From: Giles Dixon [REDACTED]
Sent: 17 August 2017 15:57
To: Anita Gardner
Subject: Re: AB/103/17/PL Former reception building.

> Subject: AB/103/17/PL Former reception building.

client:
Clarendon Properties Ltd
drawing title:
PLOTS 3&4 – Elevations

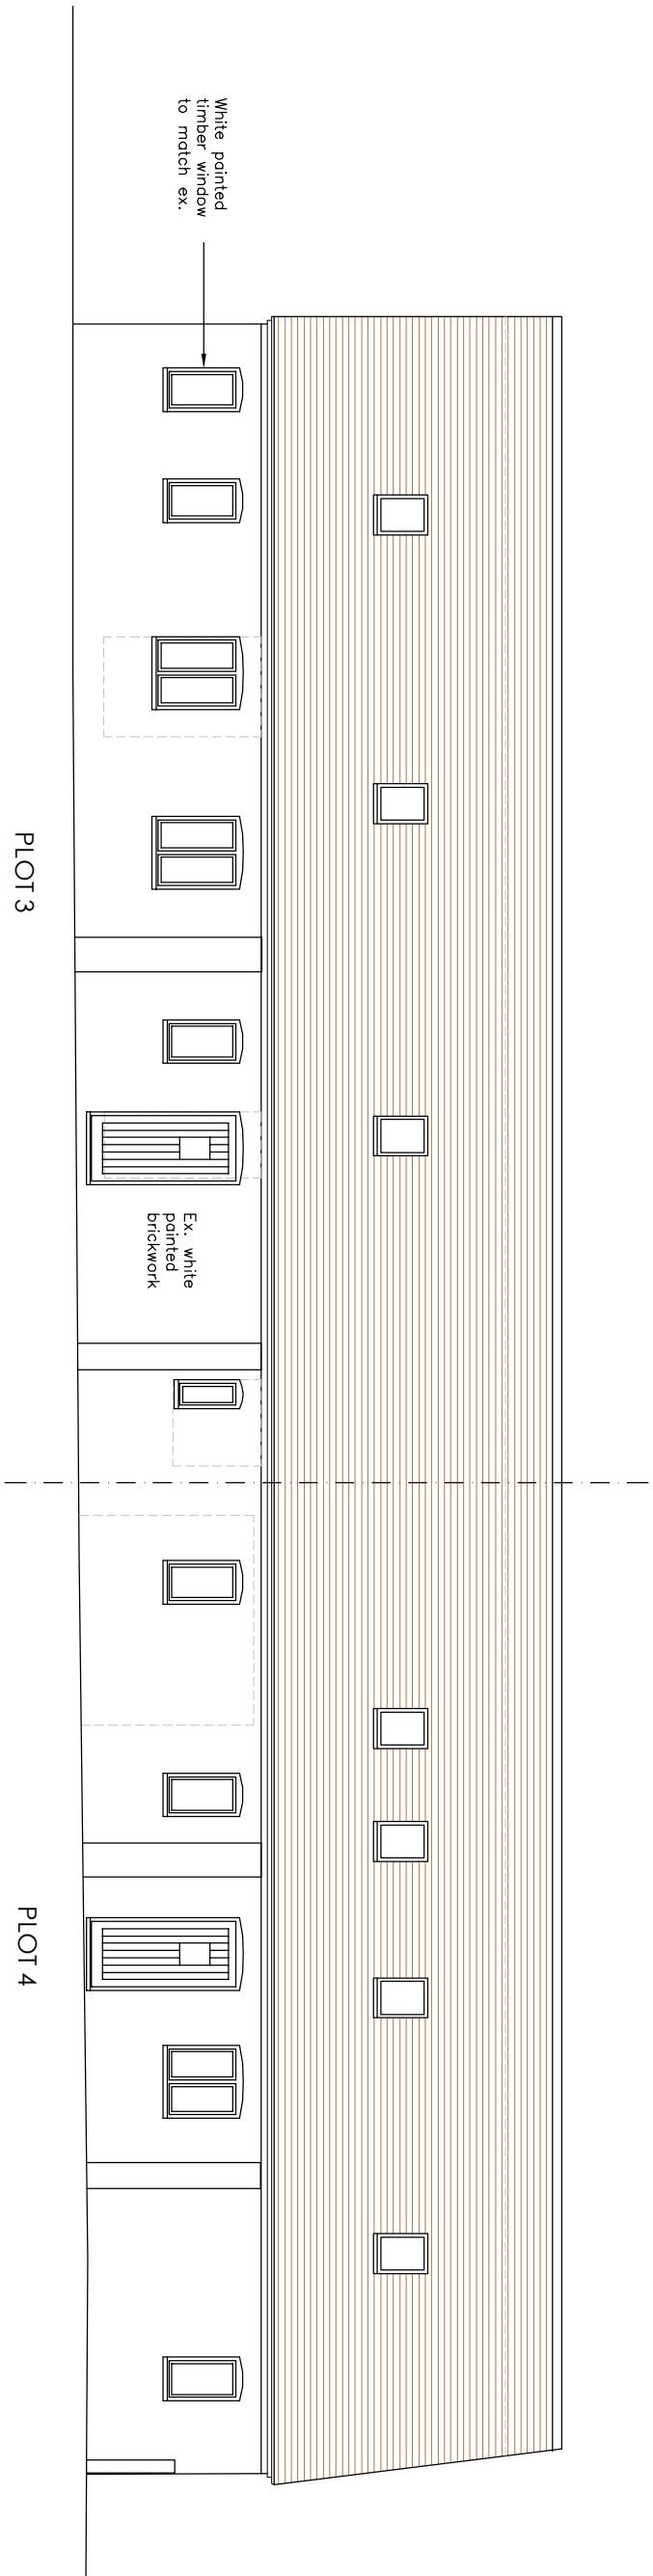
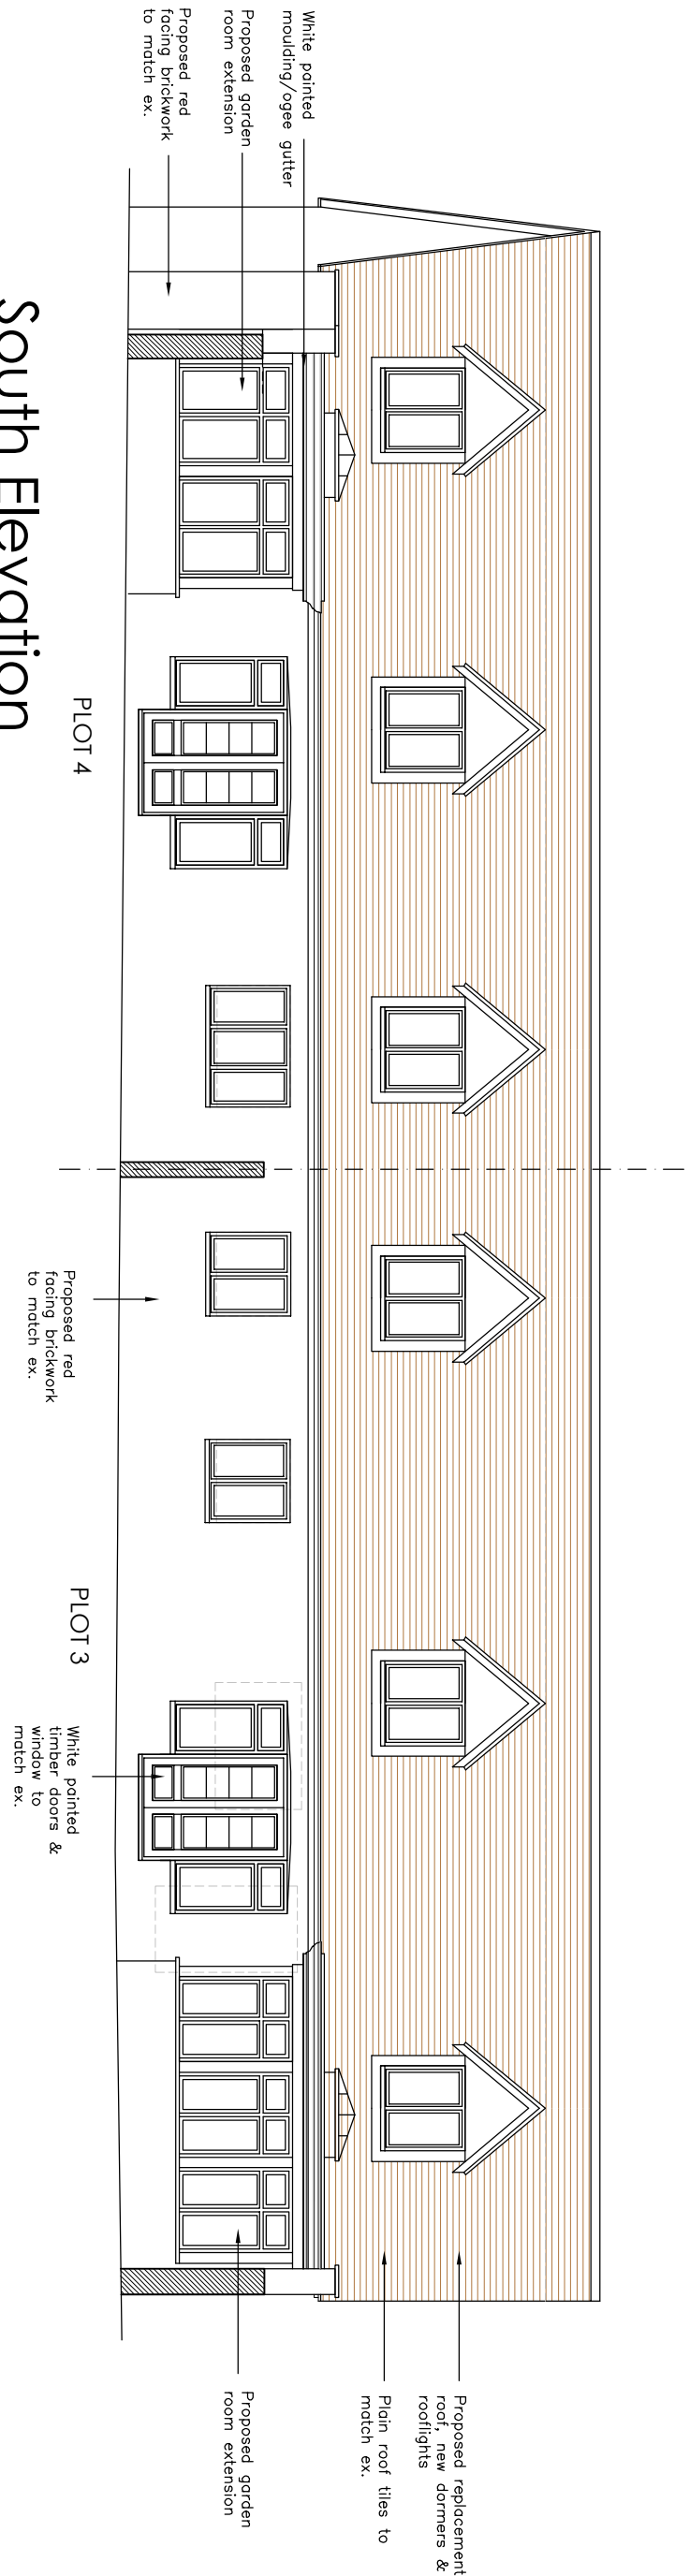
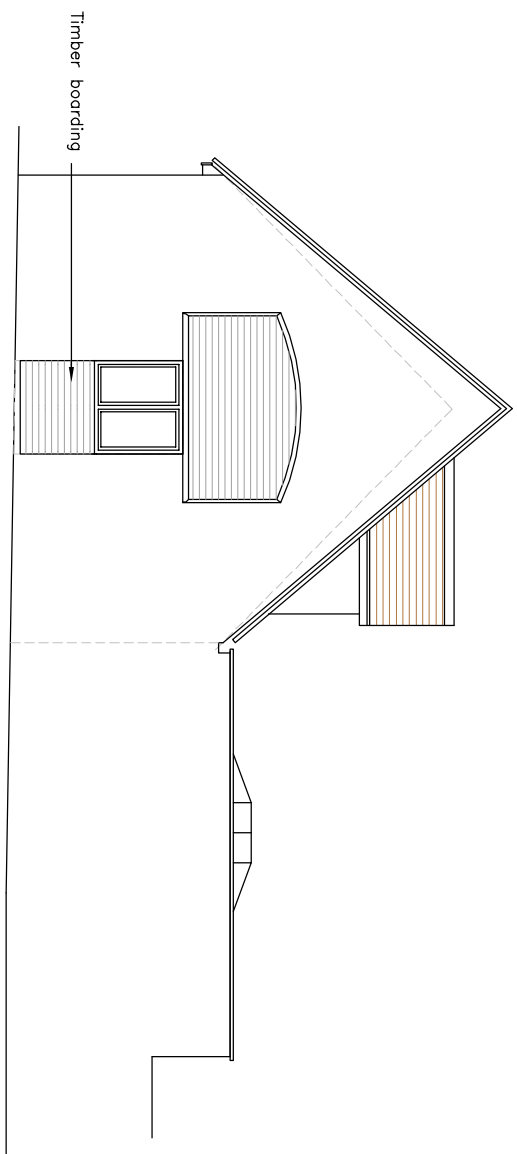
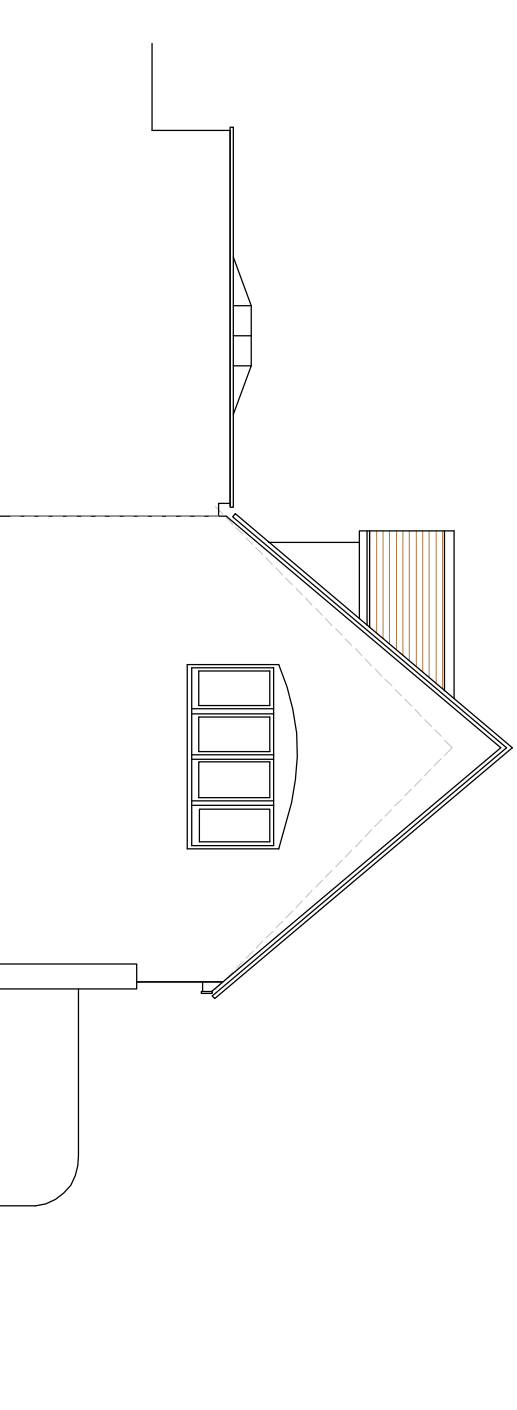
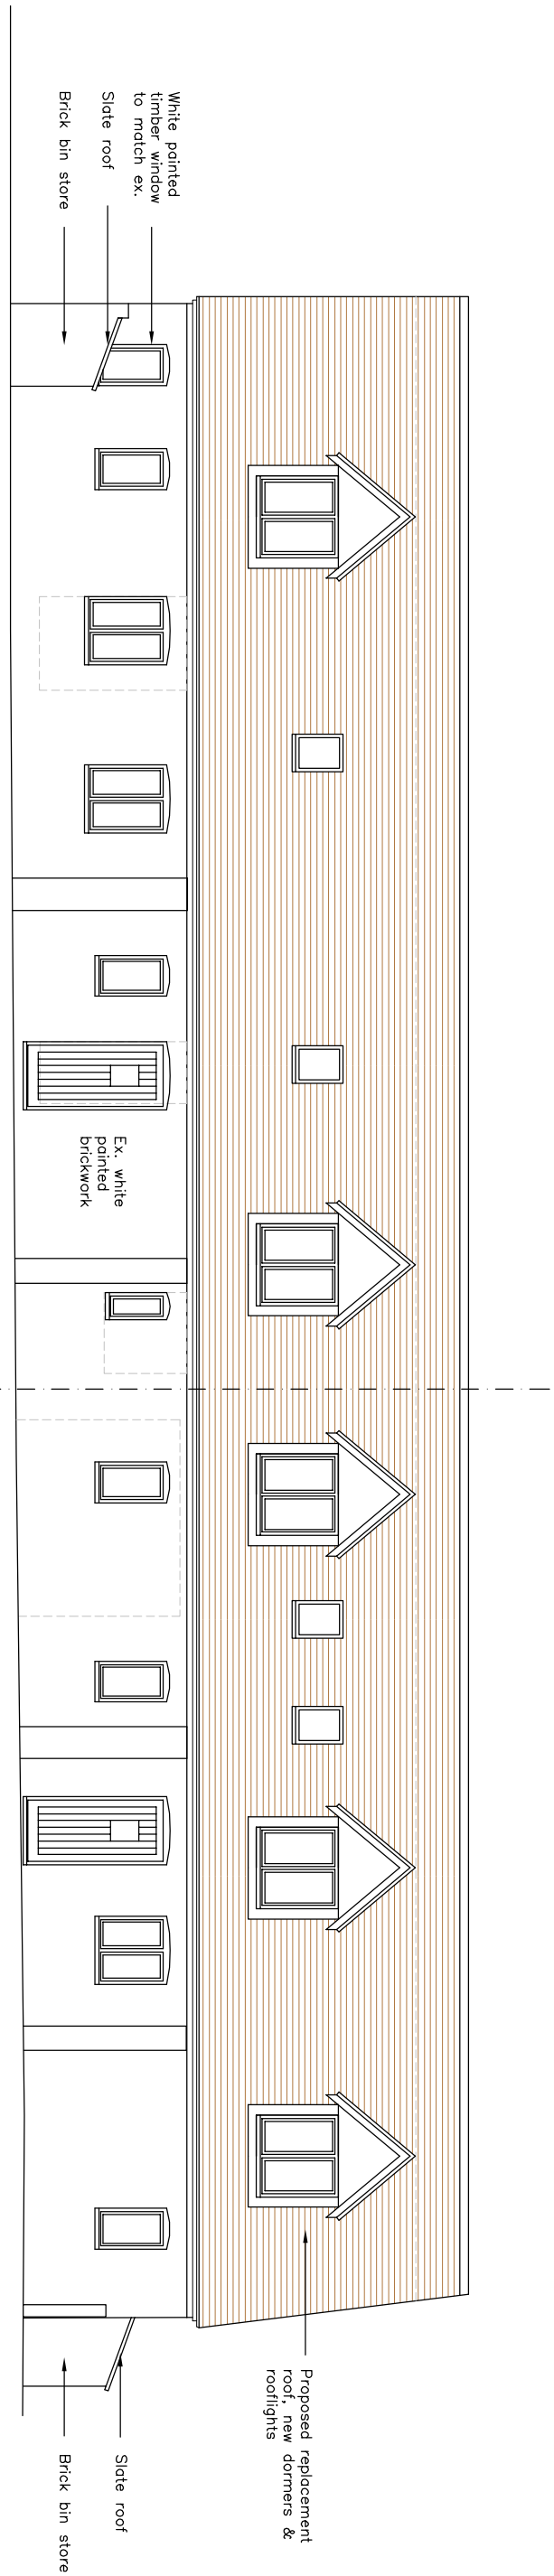
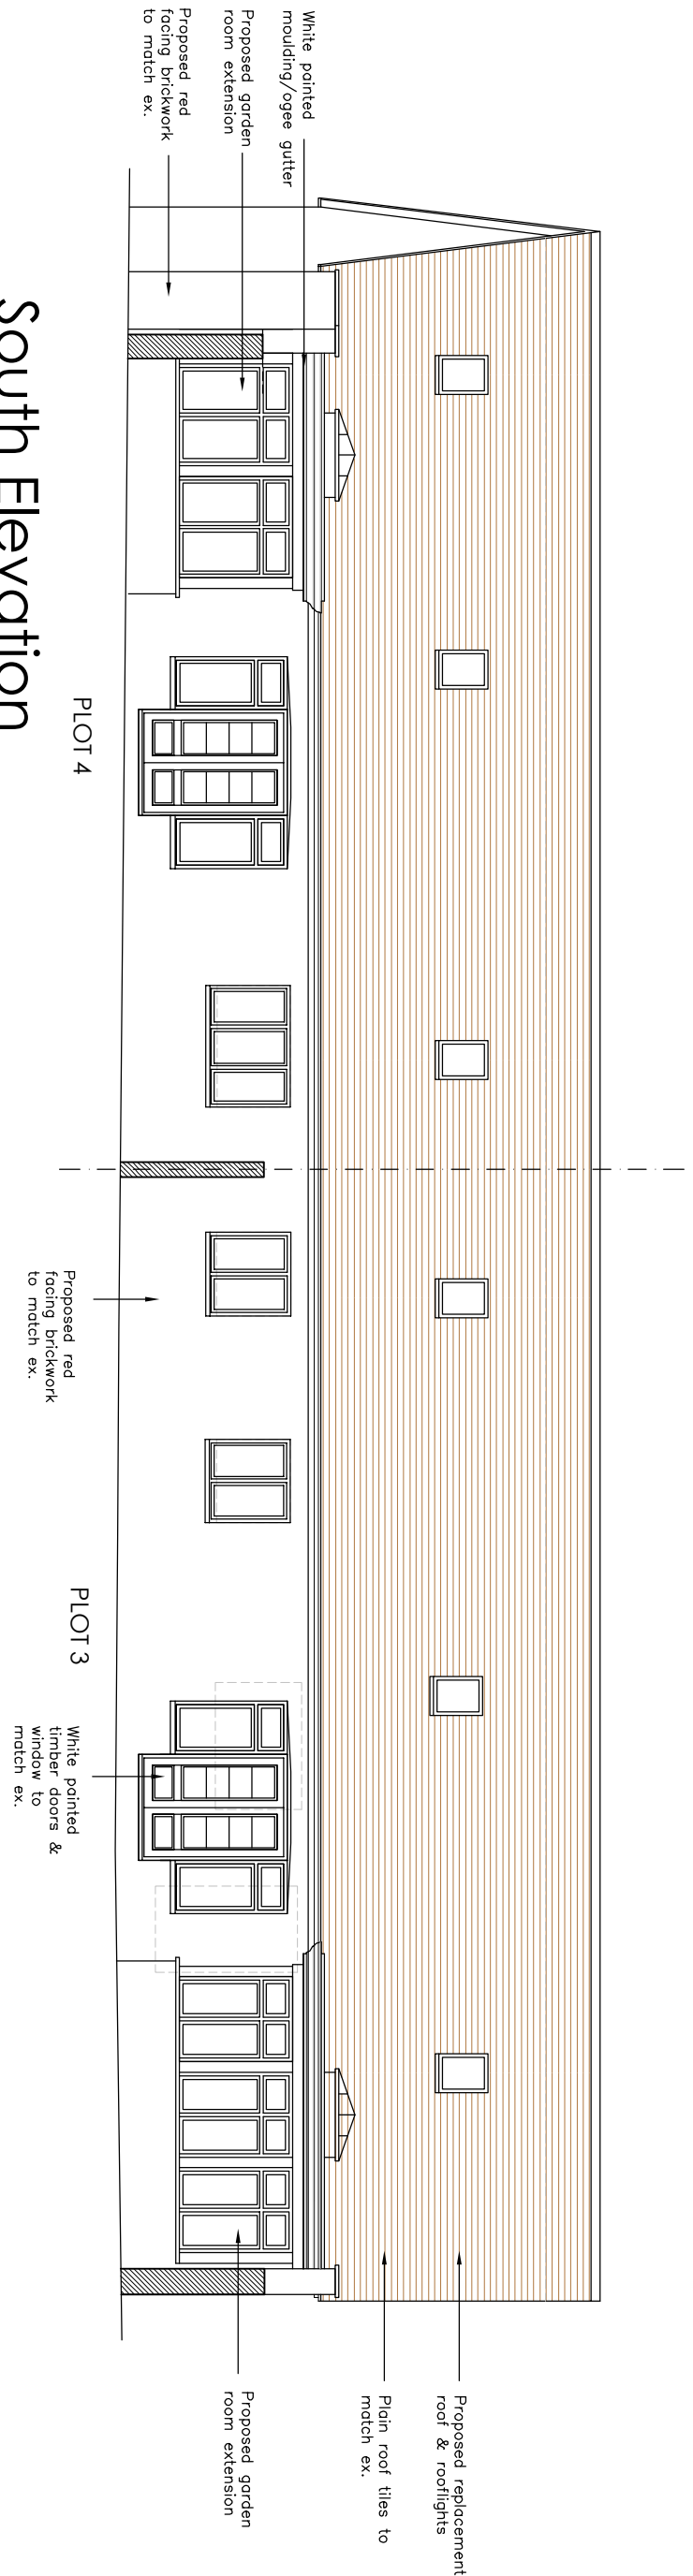
> We have been in conversation with the neighbouring homeowner to this property and they have voiced their concerns over the dormer windows to the rear of the property, potentially causing an overlooking problem.

> Therefore, please find attached amended plans showing the dormer windows relocated to the front of the building
